Please ask for: Mrs D Johnson
Email: daun.johnson@arun.gov.uk
Telephone: 01903 737762
Our Ref: LU/145/22/PL
Your Ref:
Date: 20th May 2022

Application for Planning Permission

Development: Two storey side extension and detached two storey building to north of existing house to create 4 No 3-bed dwellings. This application affects the character and appearance of the Littlehampton Seafront Conservation Area and is in CIL Zone 4 (Zero Rated) as flats.

Location: Wellesley Court Fitzalan Road Littlehampton BN17 5JW

Proposed Site

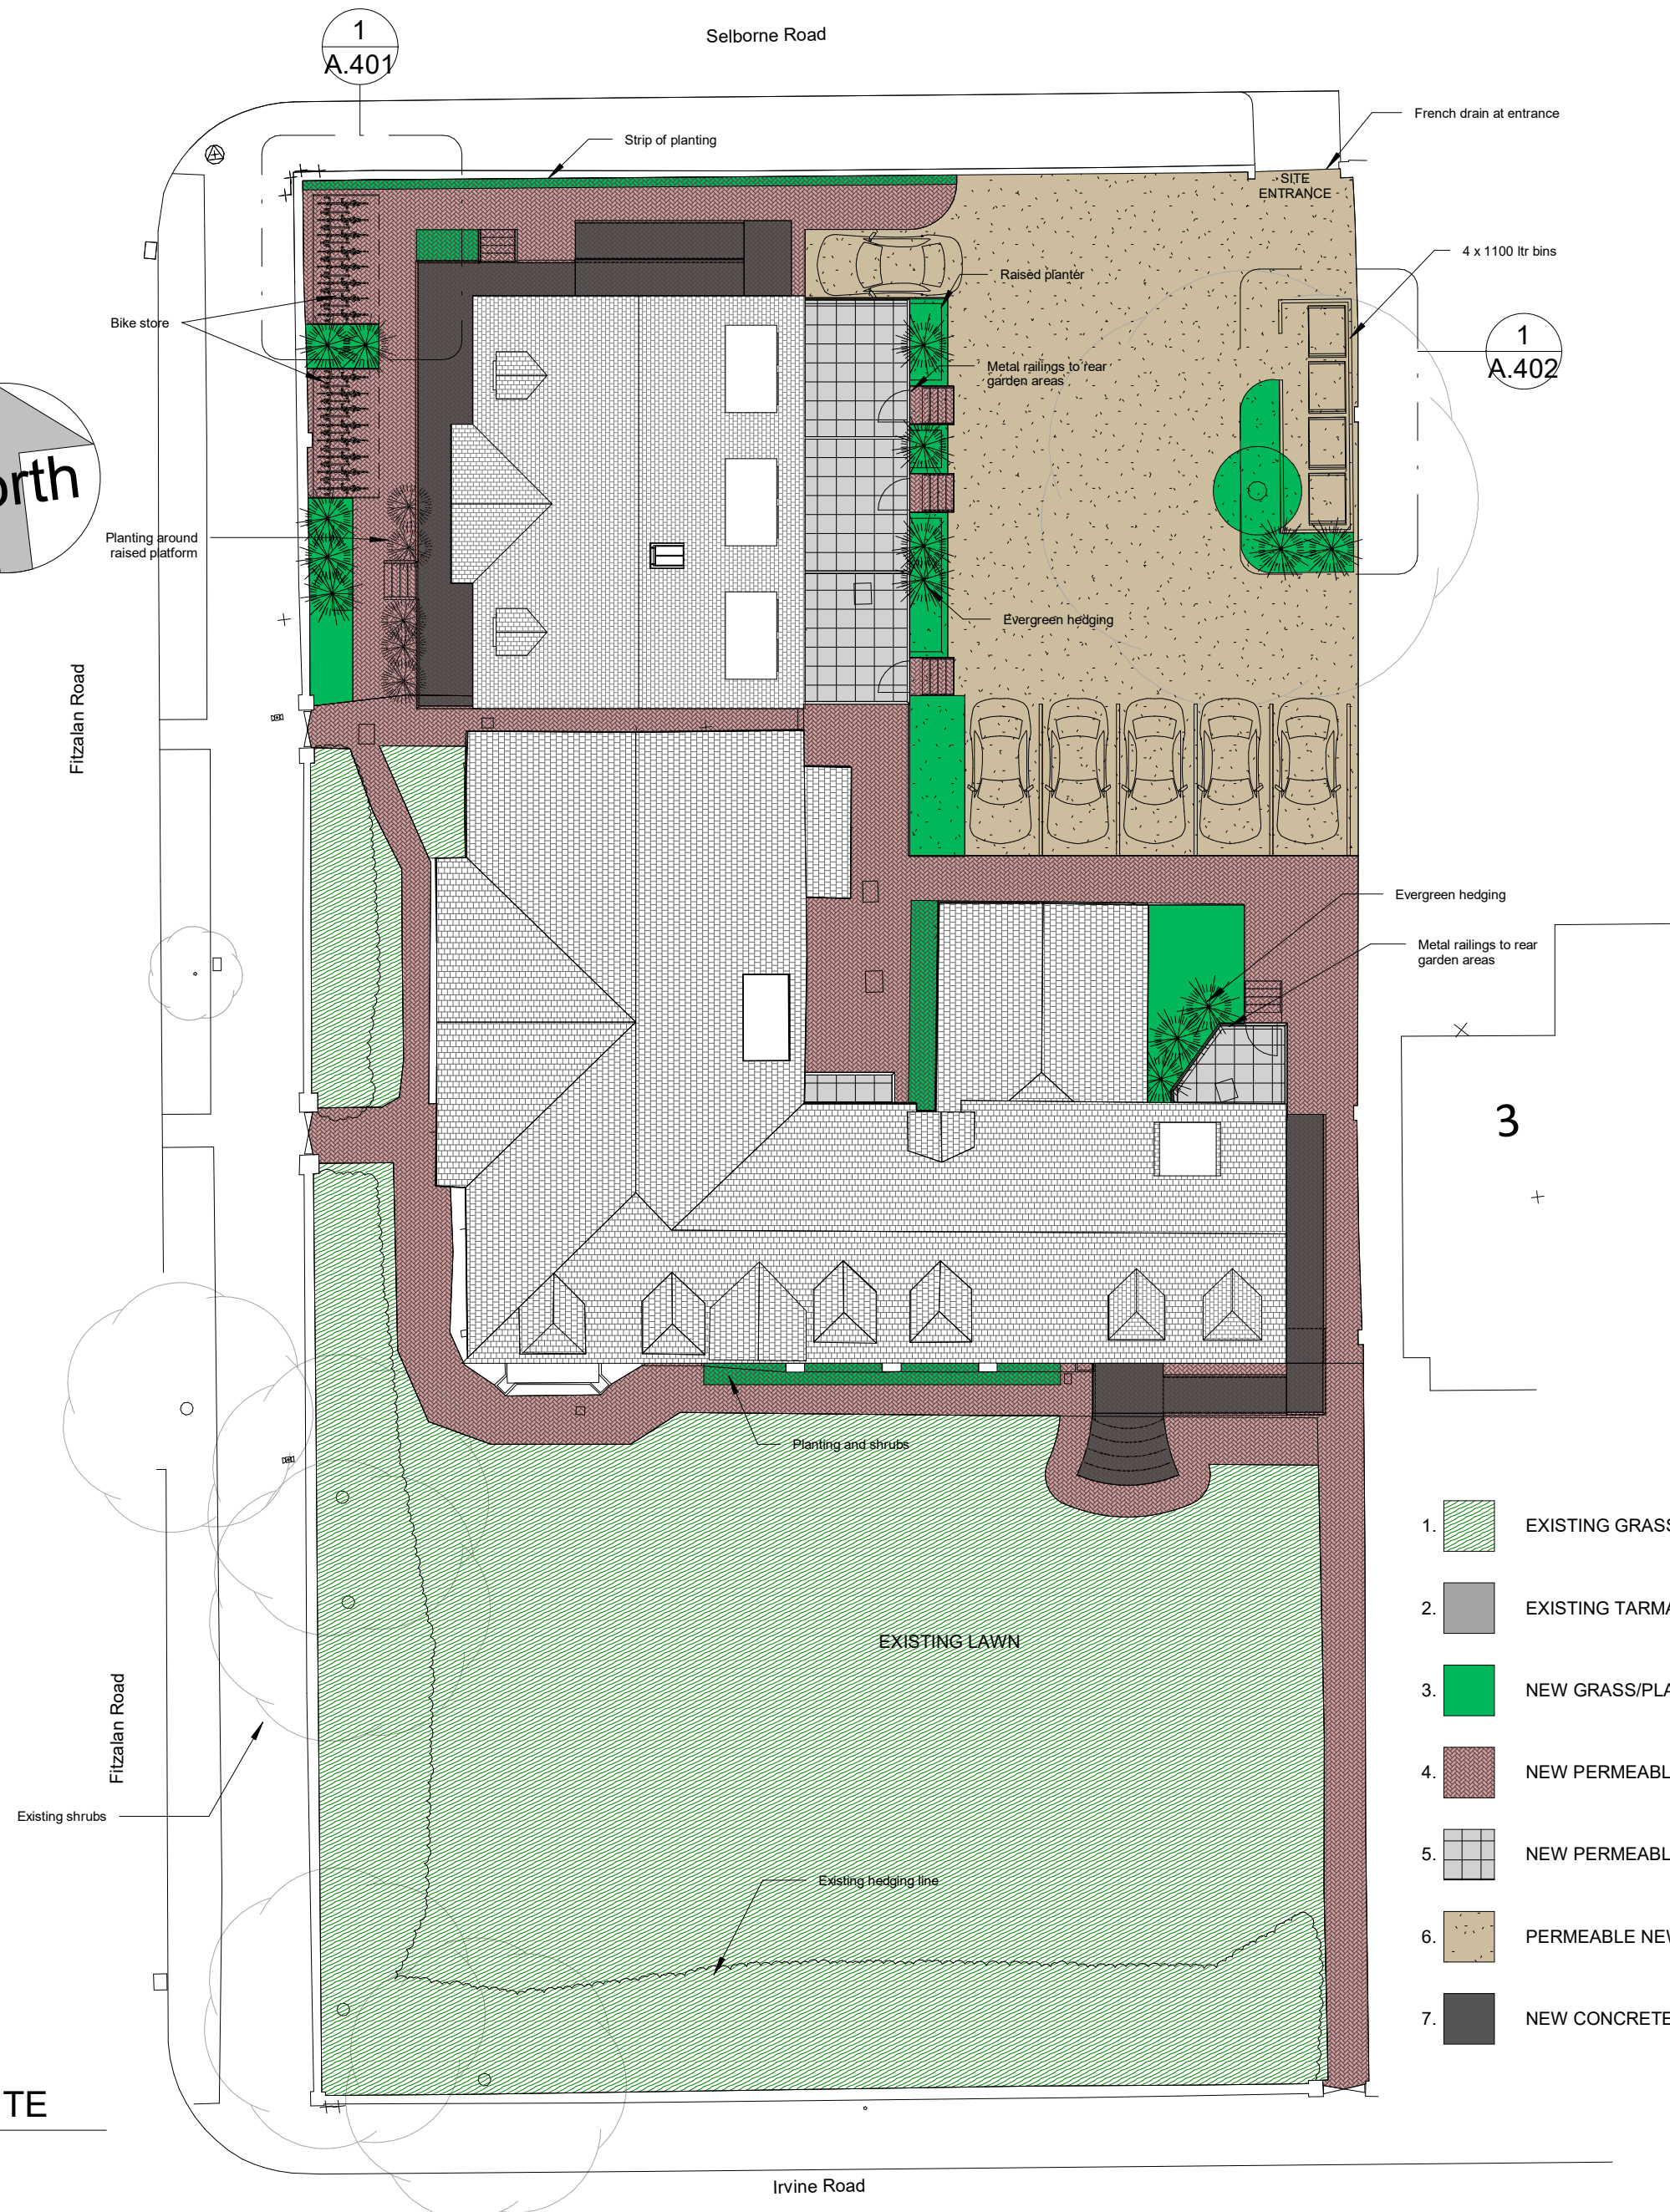
On the proposed site plan, please provide dimensions from the proposals to the site boundaries.
